**WEST SUSSEX COUNTY COUNCIL
STRATEGIC PLANNING CONSULTATION**

SUBJECT: BR/161/13 - Dropped kerb, for driveway.

2, Corbishley Road, Bognor Regis, West Sussex, PO22 9HR

Scale 1:500

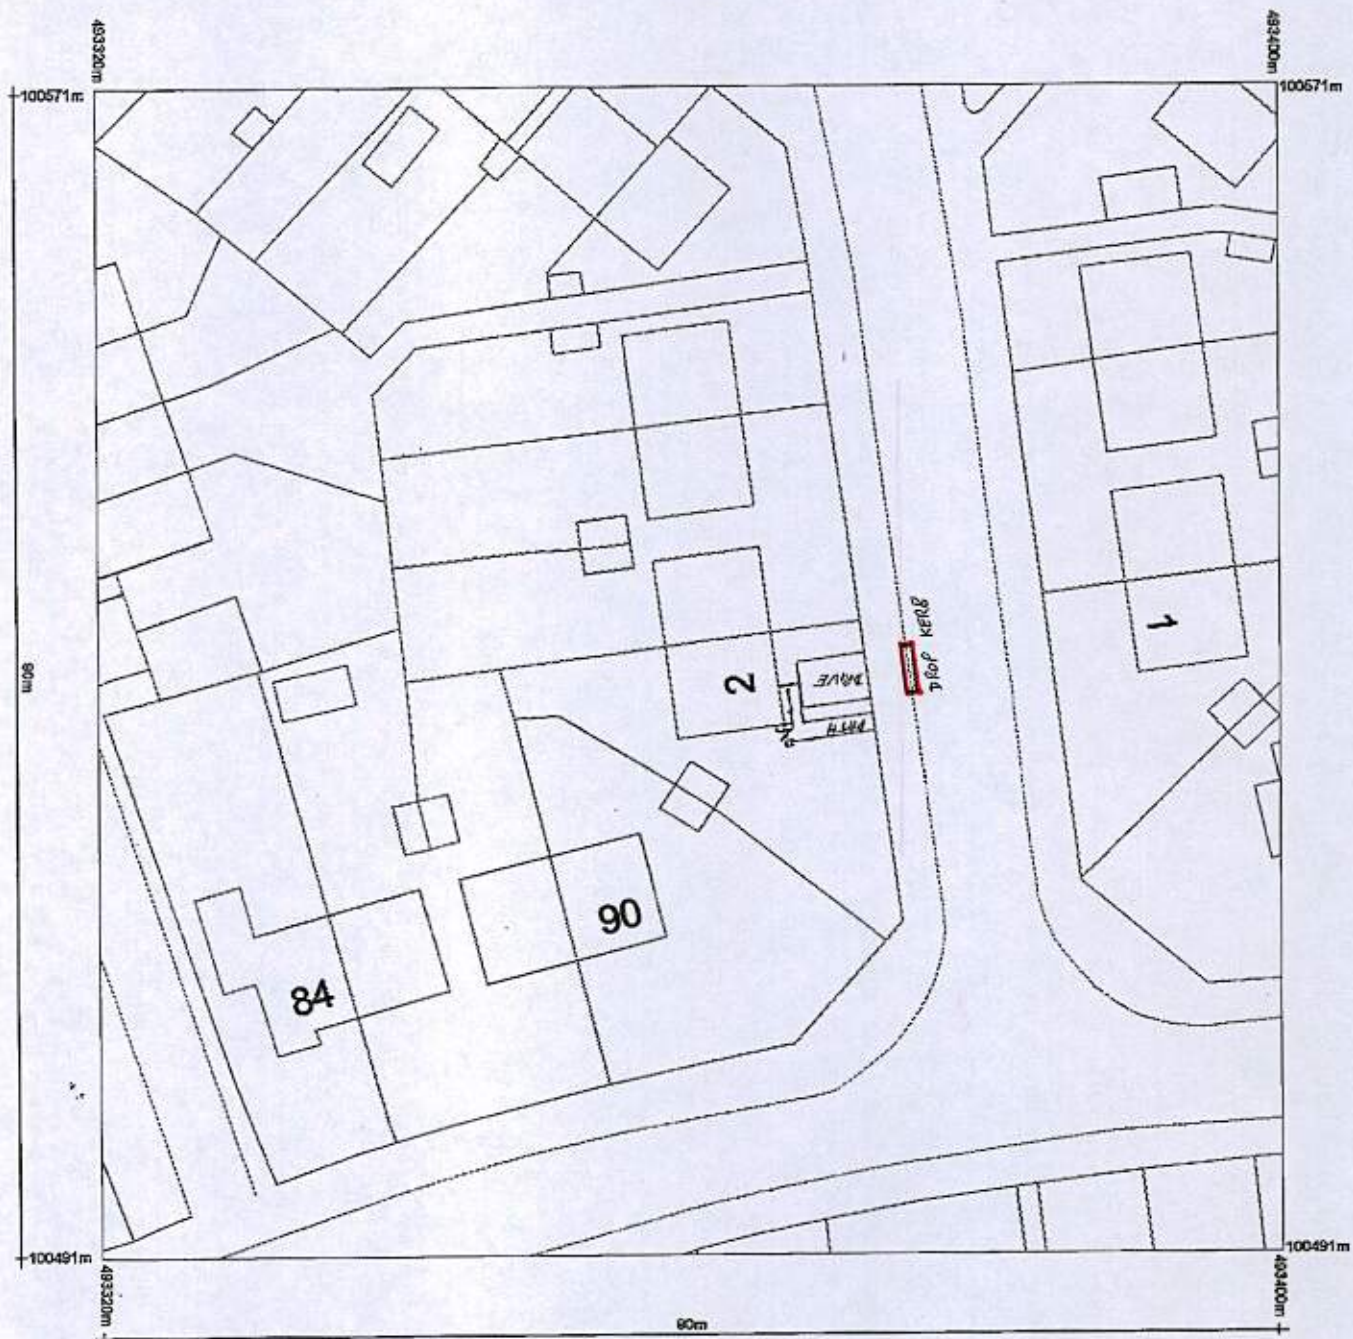
2x2 pedestrian visibility splays should be provided, these will have an impact on the adjacent hedging and can be secured via condition.

The off street car parking space should measure 2.4 x 4.8 metres and from scaling the plans provided this would be achievable, even though it has not been fully demonstrated on the plans provided. I would be minded to ask that the plans and details of the off street car parking space are secured via condition and constructed in a bound surface.

No part of the development shall be first occupied until pedestrian visibility splays of 2 metres by 2 metres have been provided either side of the proposed site vehicular access onto Corbishley Road in accordance with plans and details submitted to and approved in writing by the Local Planning Authority. These visibility splays shall thereafter be kept free of all obstructions over a height of 0.6 metre above adjoining carriageway level or as otherwise agreed.

No part of the development shall be first occupied until the car parking spaces have been constructed in accordance with plans and details submitted to and approved in writing by the Local Planning Authority. These spaces shall thereafter be retained at all times for their designated use.
